Final Plat Drawings_V2.pdf Markup Summary

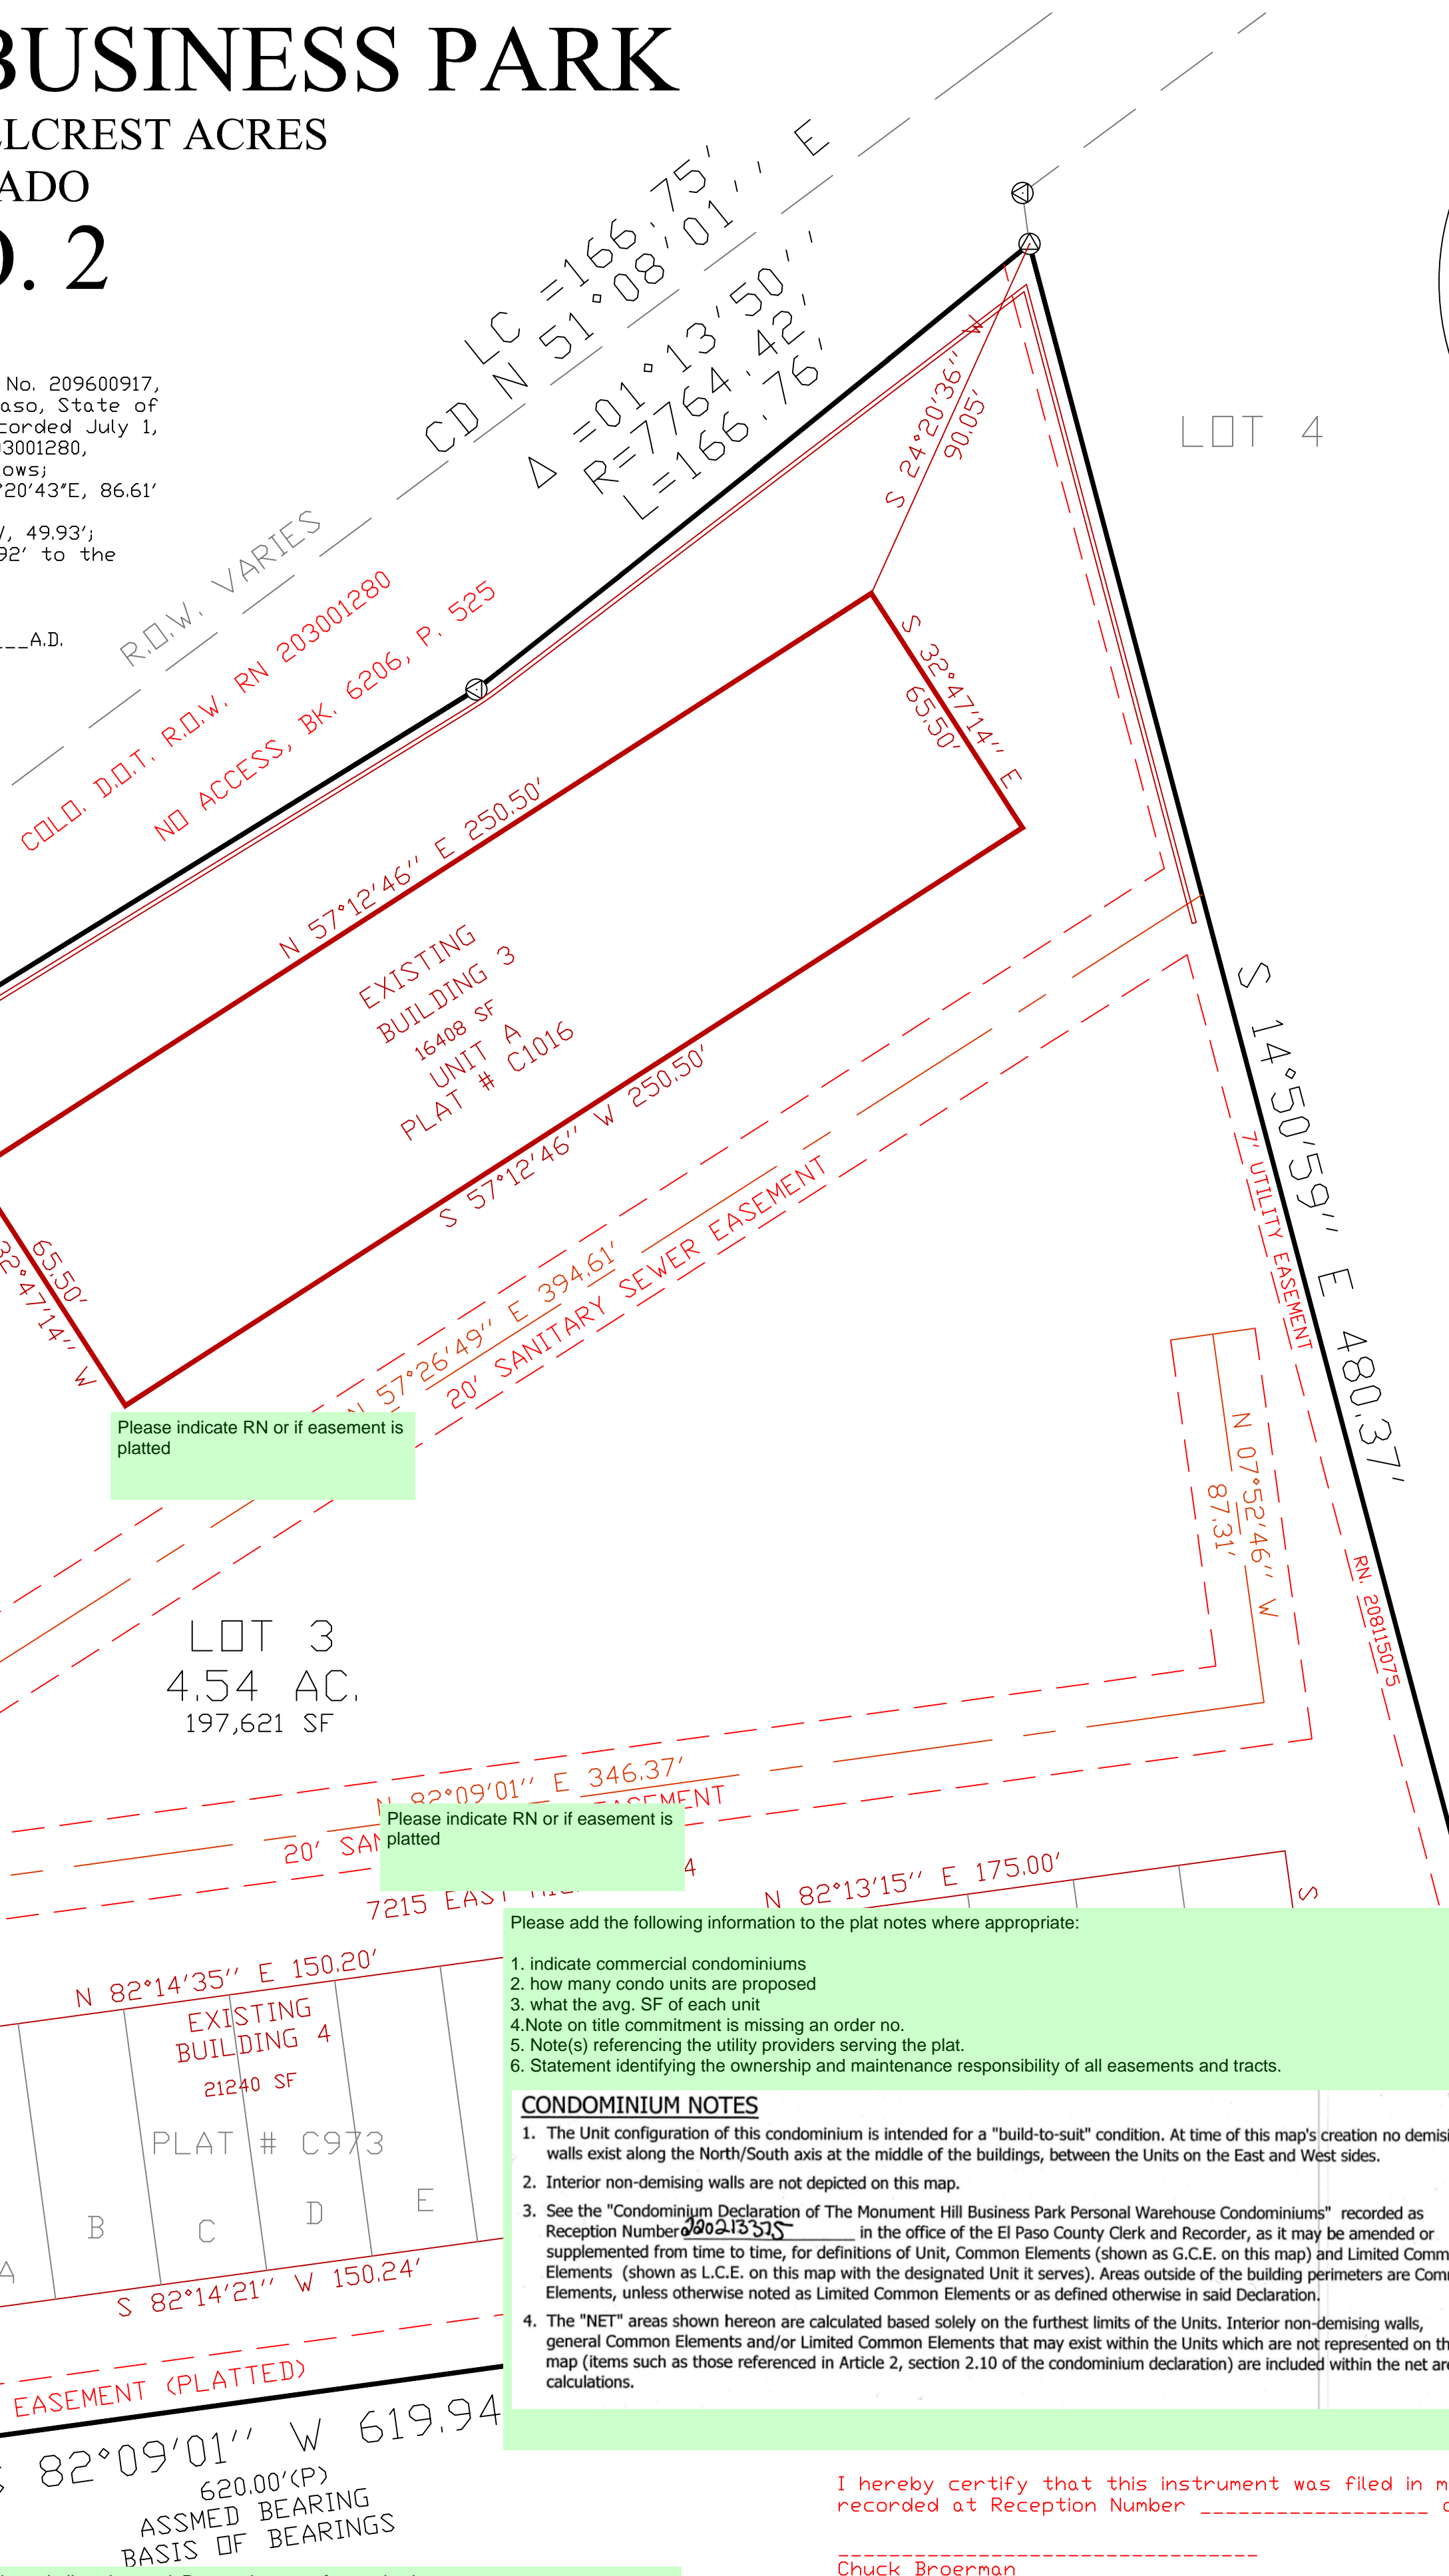
[Repeat Comment: Please add the following information to the plat notes where appropriate:

1. indicate the use - commercial condominiums
2. how many condo units are proposed
